BE/46/26/PL

Address: Shripney Manor Shripney Lane Bersted PO22 9NU

Proposal: Installation of 100 No solar panels. This application may affect the Shripney Conservation Area and is in CIL Zone 3 (Zero Rated) as other development

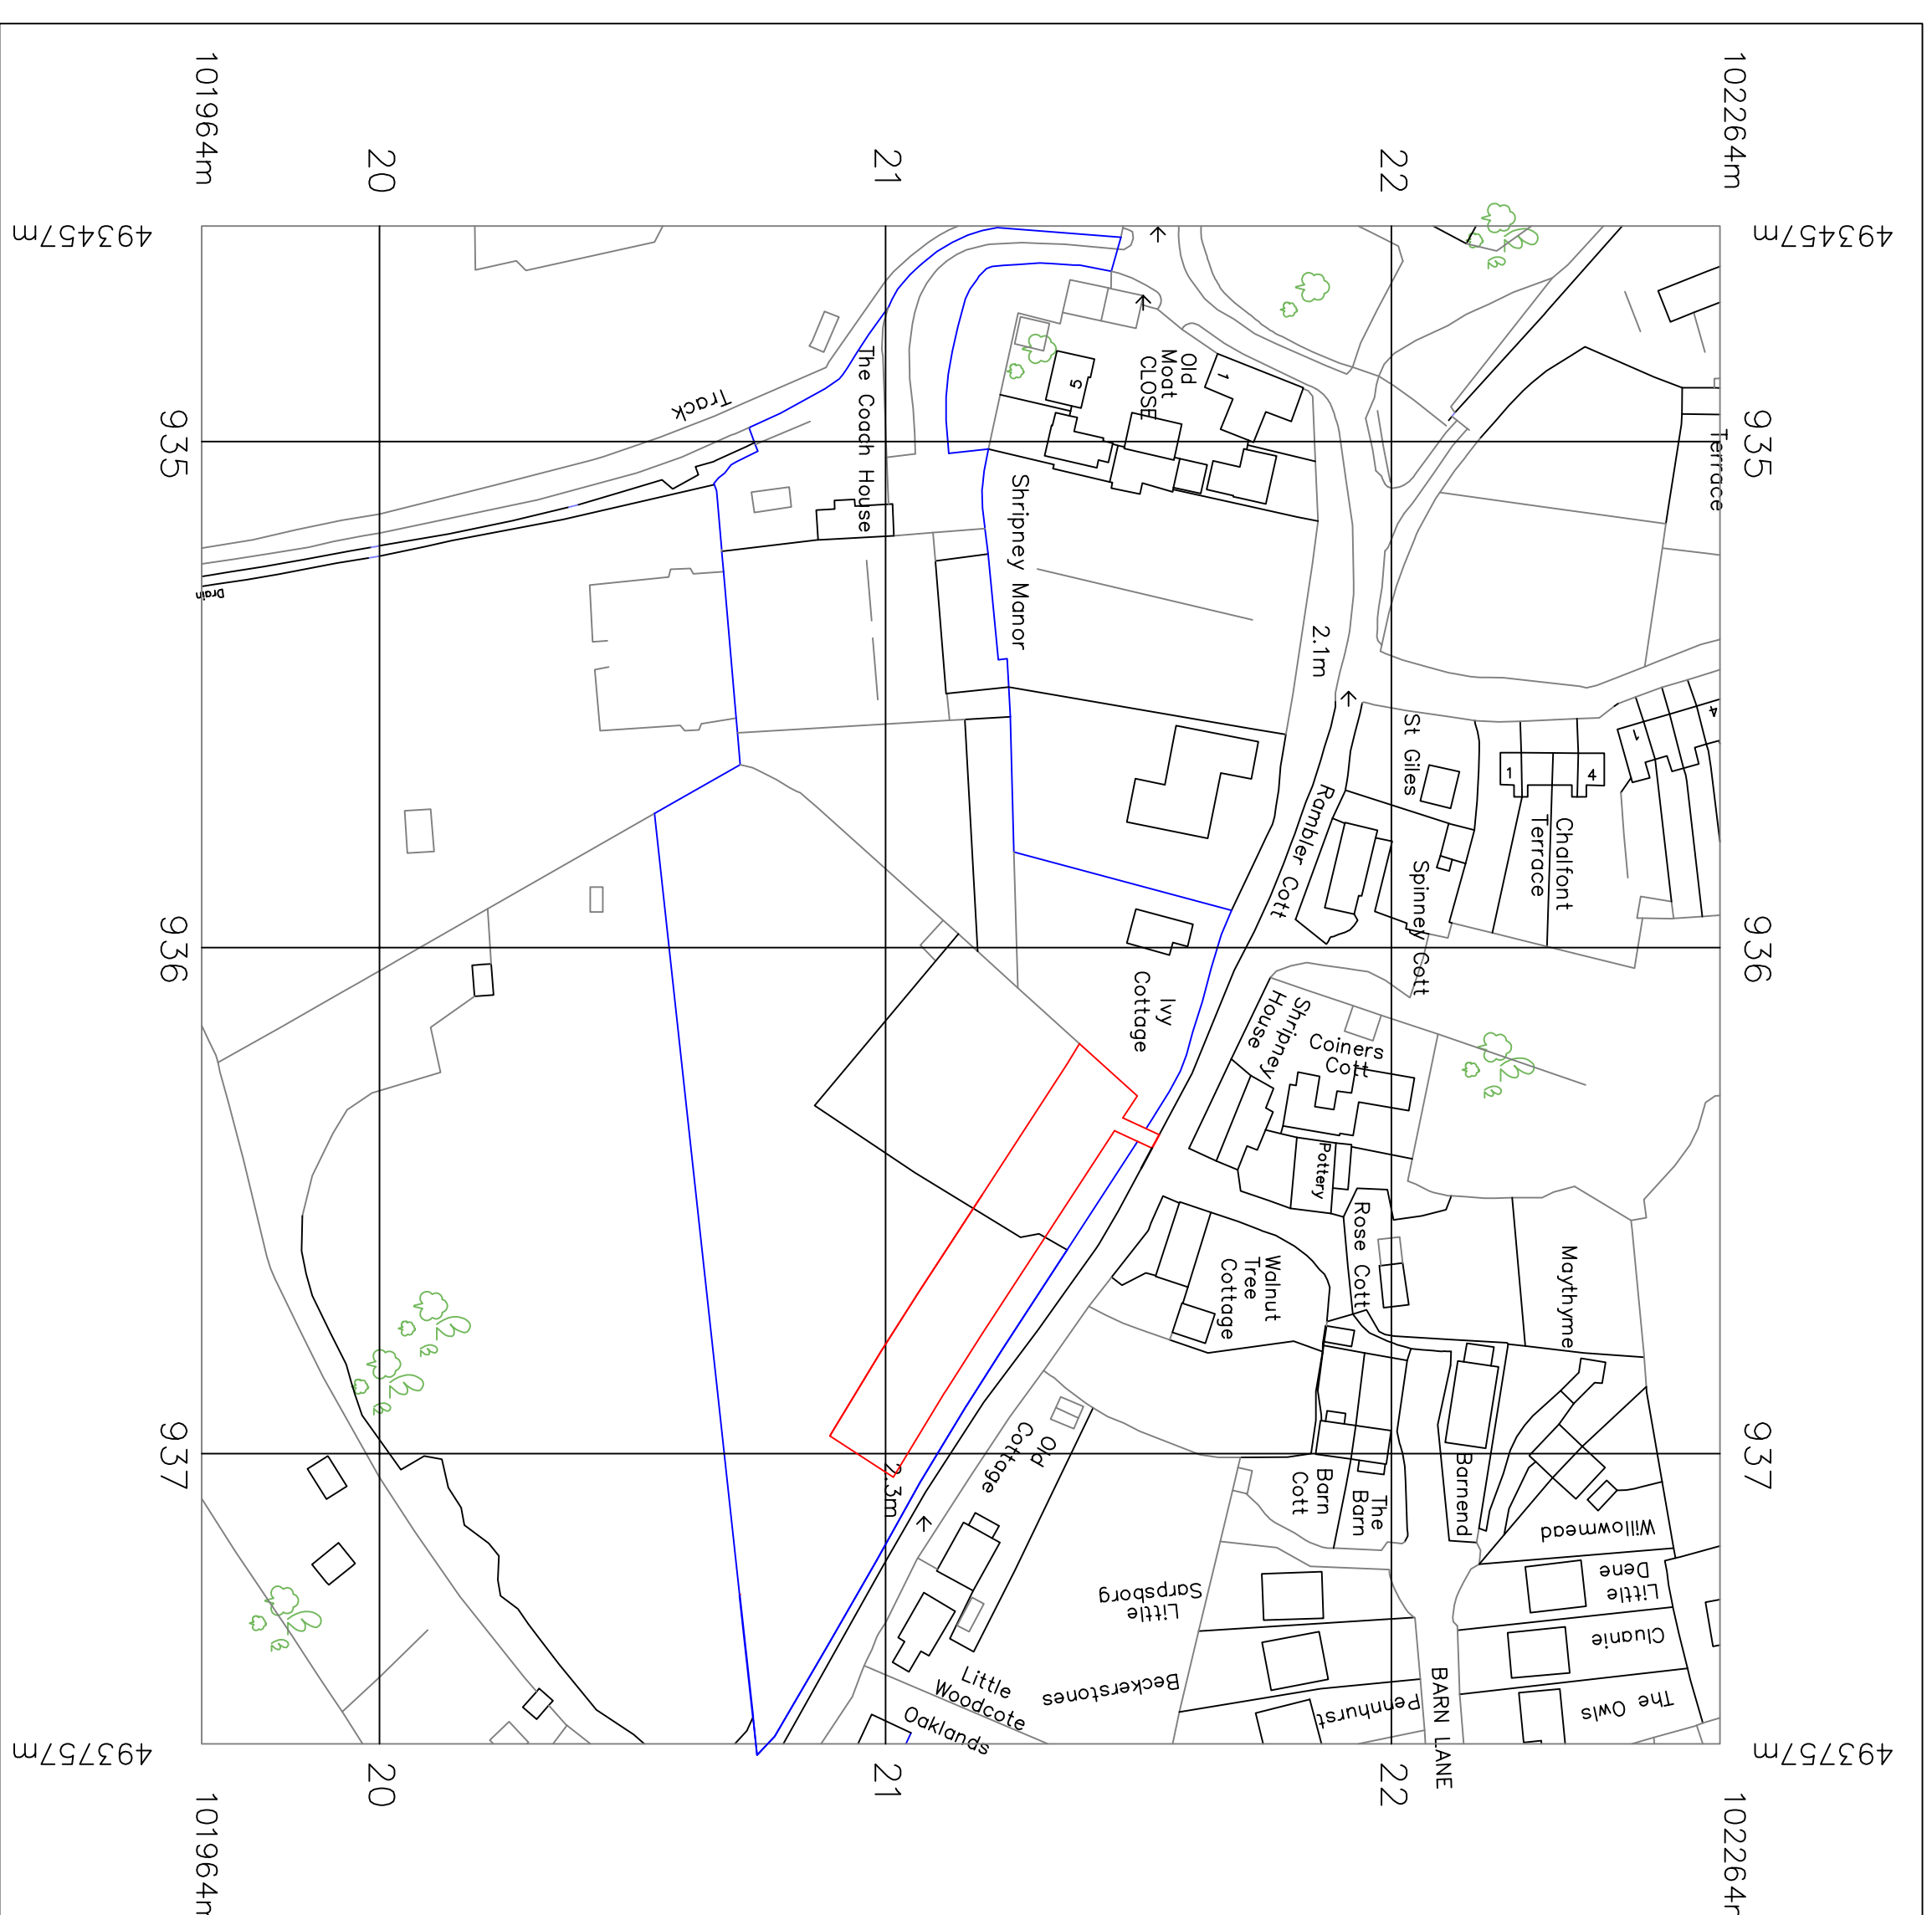
The advice from Historic England also states that “consideration should be given to reducing the visual impact of ground mounted panels in the setting of listed buildings, for instance using hedges to screen them and designing unobtrusive security measures”. At present, it is not clear if any form of boundary treatment will be installed to enclose the area (i.e. the other boundary treatments), nor what these would be/look like. This needs to be clarified.

It is also not clear how or where the electricity supply cable to the main listed building will be located or connected to the listed building. This needs to be clarified.
